From: Nicola Moore on behalf of Planning.Responses
Sent: 24 July 2019 09:11
To: Planning Scanning
Subject: FW: WA/36/19/HH & WA/37/19/L

WA/36/19/HH & WA/37/19/L

Additional comments

CLIENT	Mr & Mrs J Waights	SCALE	1:100 @ A3
SITE	Holly Tree Cottage, The Street, Walberton	STATUS	PL / LBC
PROJECT	Proposed First Floor Extension	AUTHOR	AH
DRAWING	002 Proposed Garage & Roof Plans	DATE	23 04 19

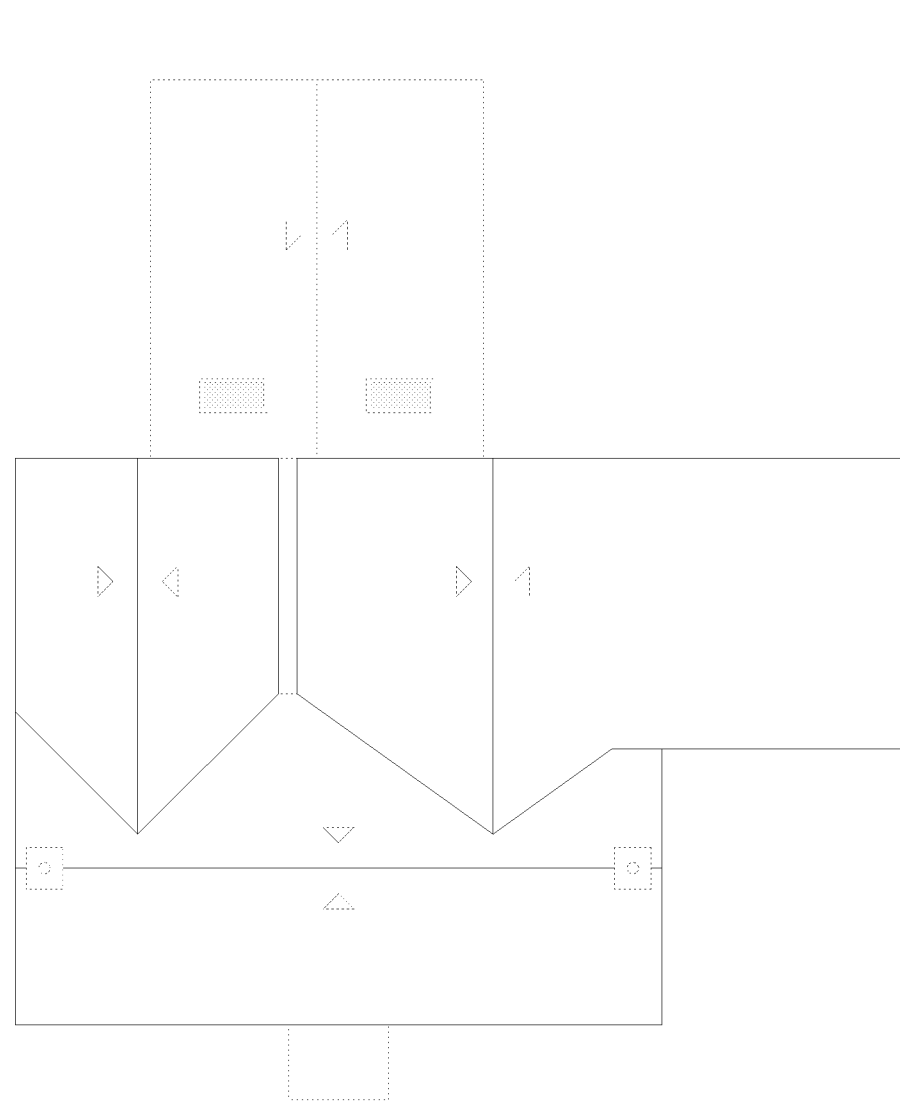
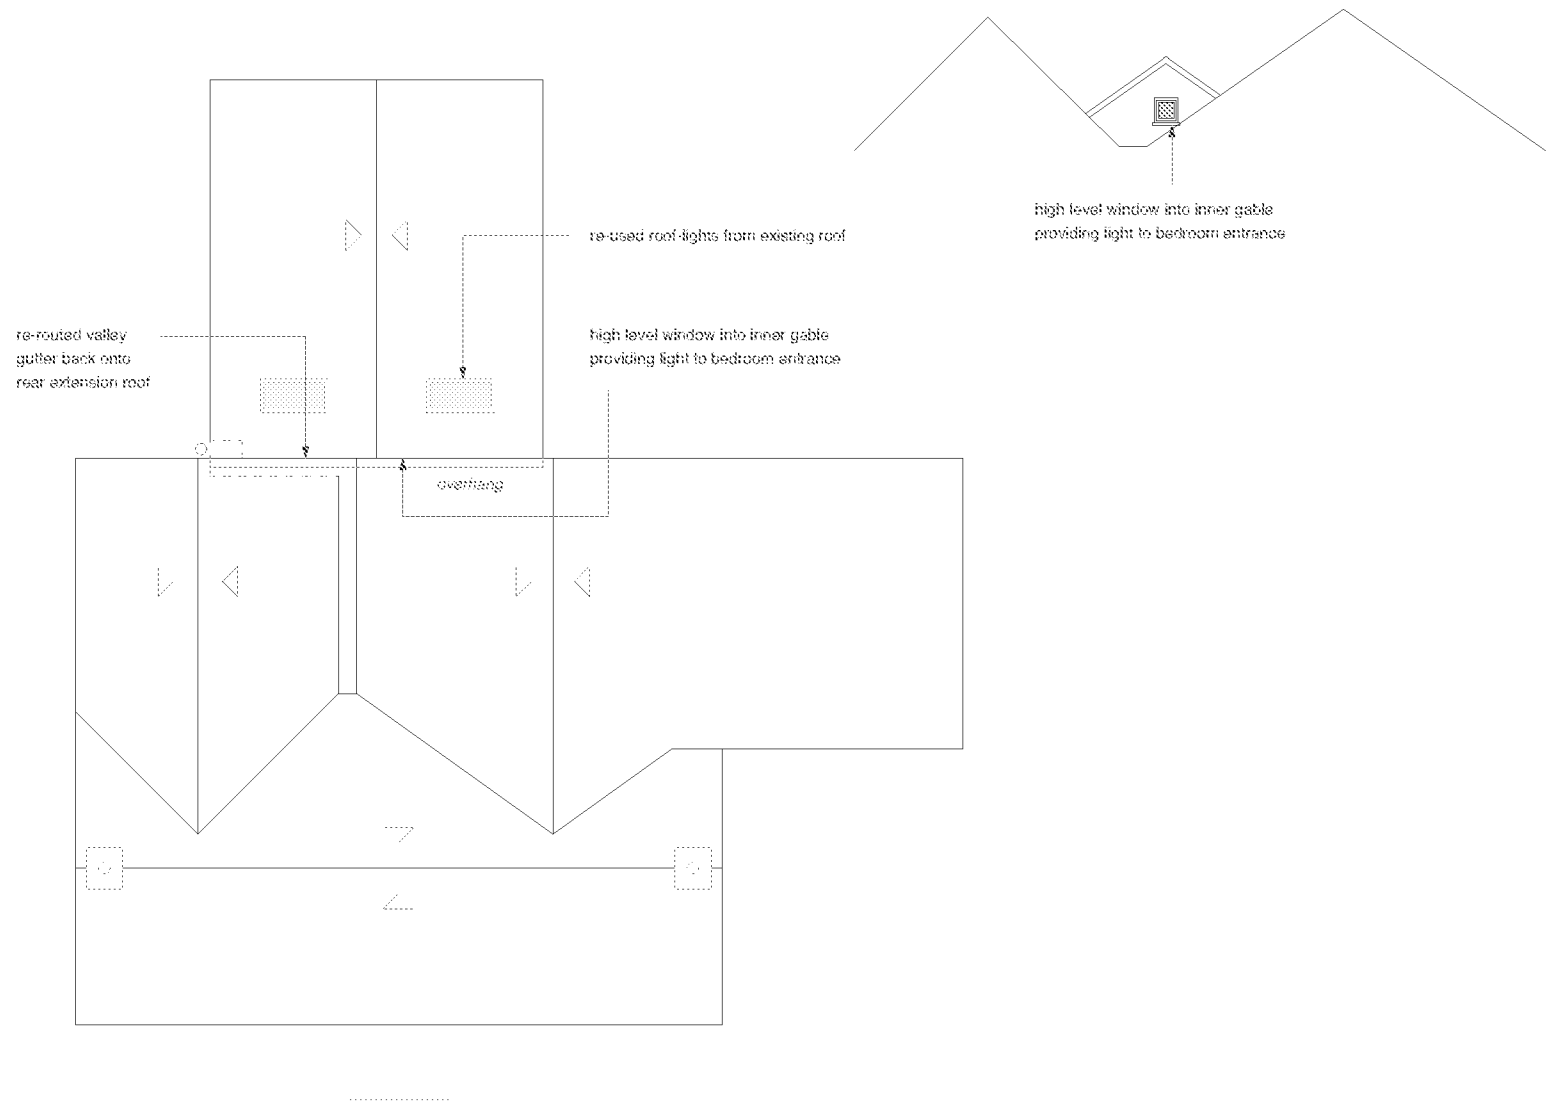
I note that revised plans have been submitted regarding this proposal. These revised plans remove the proposed garage/carport structure. Such an amendment is positive and reduces the harm to both the conservation area and the listed building.

CLIENT	Mr & Mrs J Waights	SCALE	1:100 @ A3
SITE	Holly Tree Cottage, The Street, Walberton	STATUS	PL / LBC
PROJECT	Proposed First Floor Extension	AUTHOR	AH
DRAWING	001 Existing & Proposed Floor Plans	DATE	23 04 19

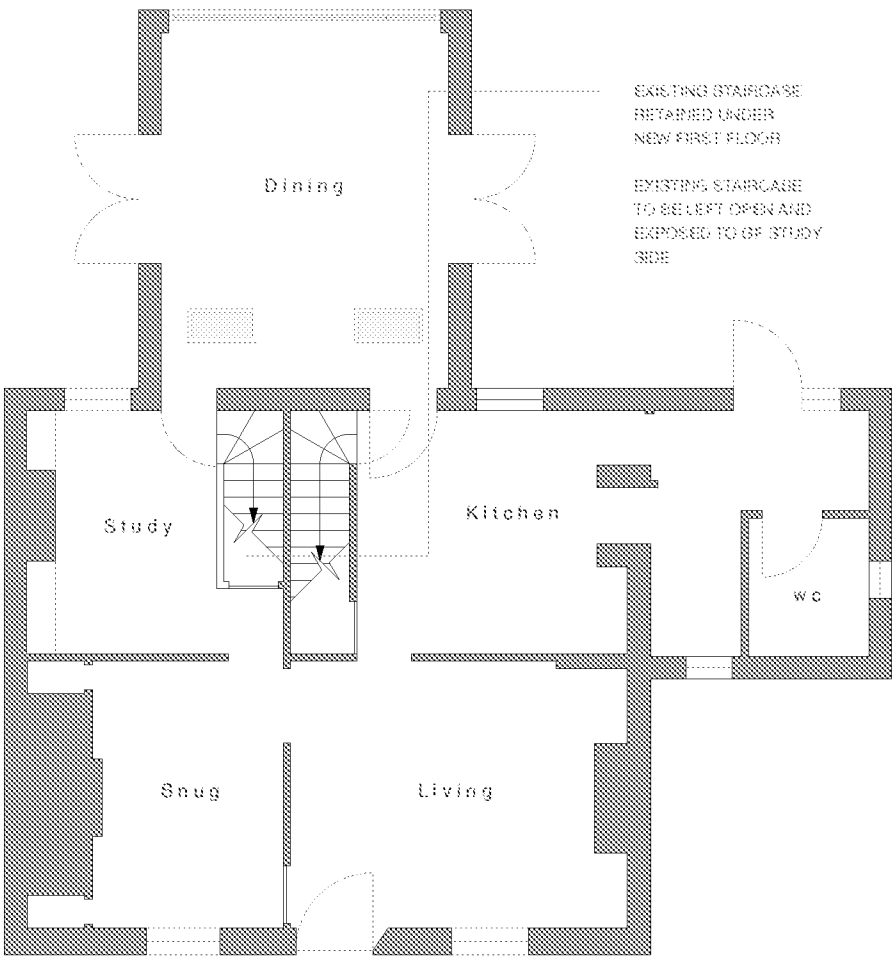
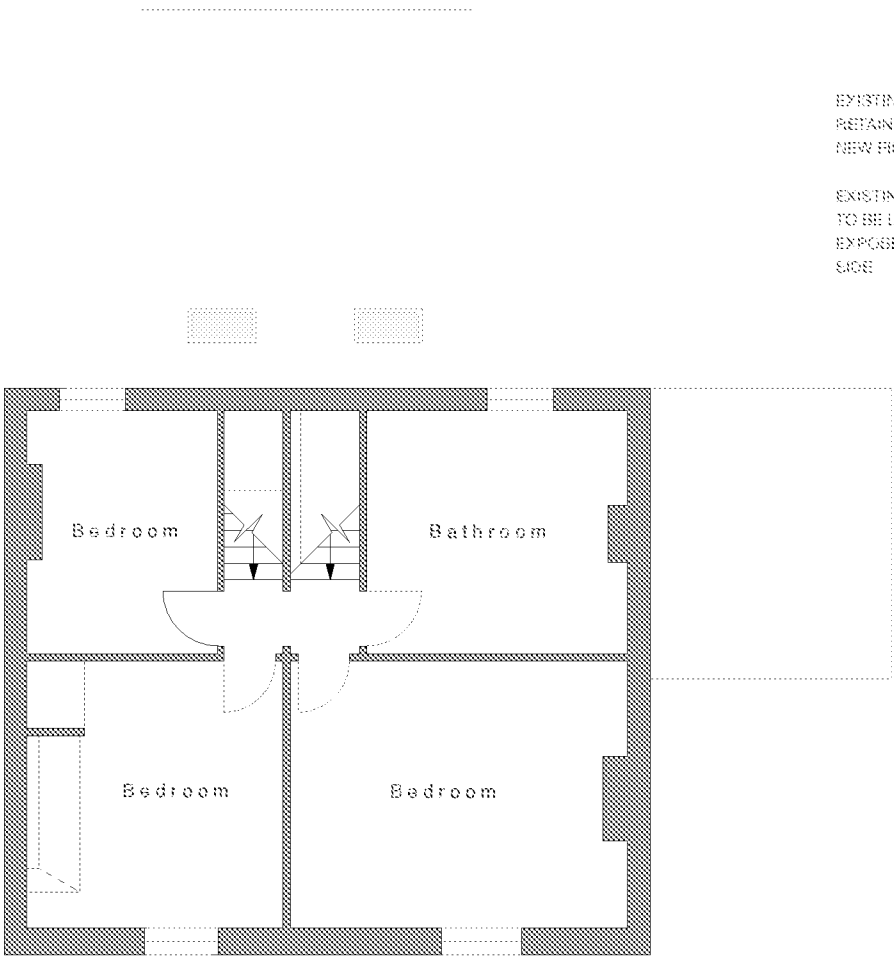
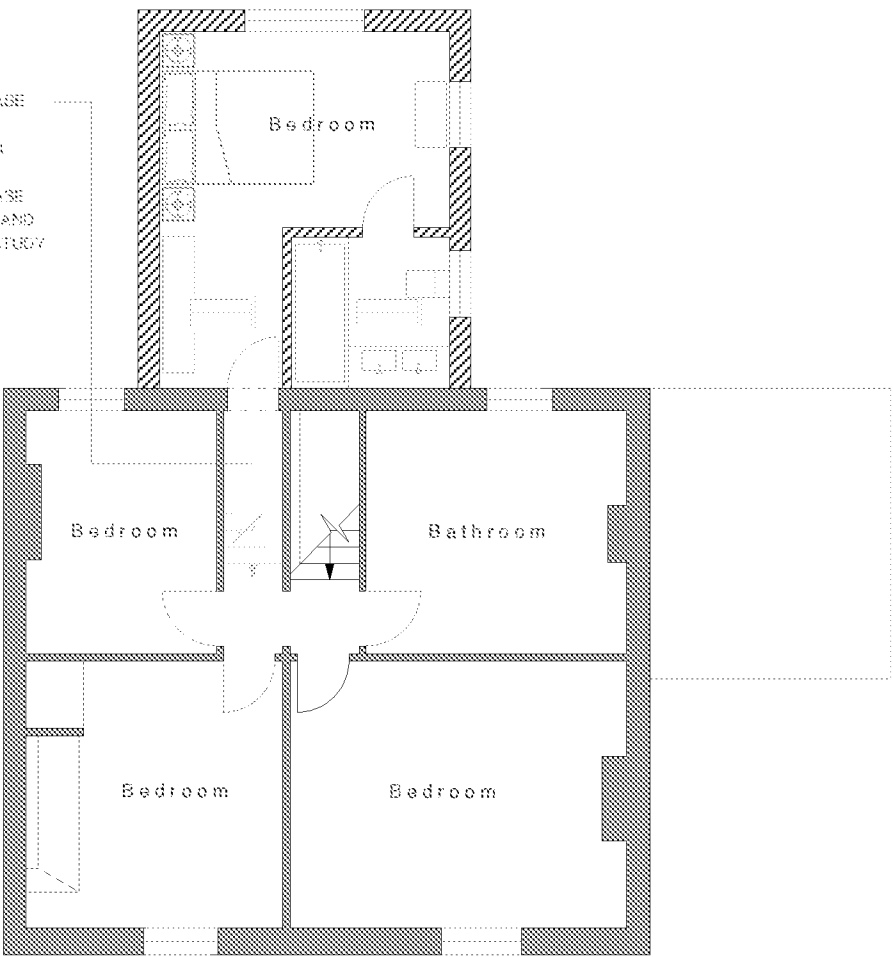
I also note that reference is now included that the stair case will be retained in-situ, but that flooring will be inserted at the top in order to provide level access to the extension. This will ensure that the stairs remain for future reference.

Whilst this element of the proposal is generally acceptable, more detailed information could be provided for by way of condition. This will indicate how the floor will be inserted without harming the surrounding historic fabric.
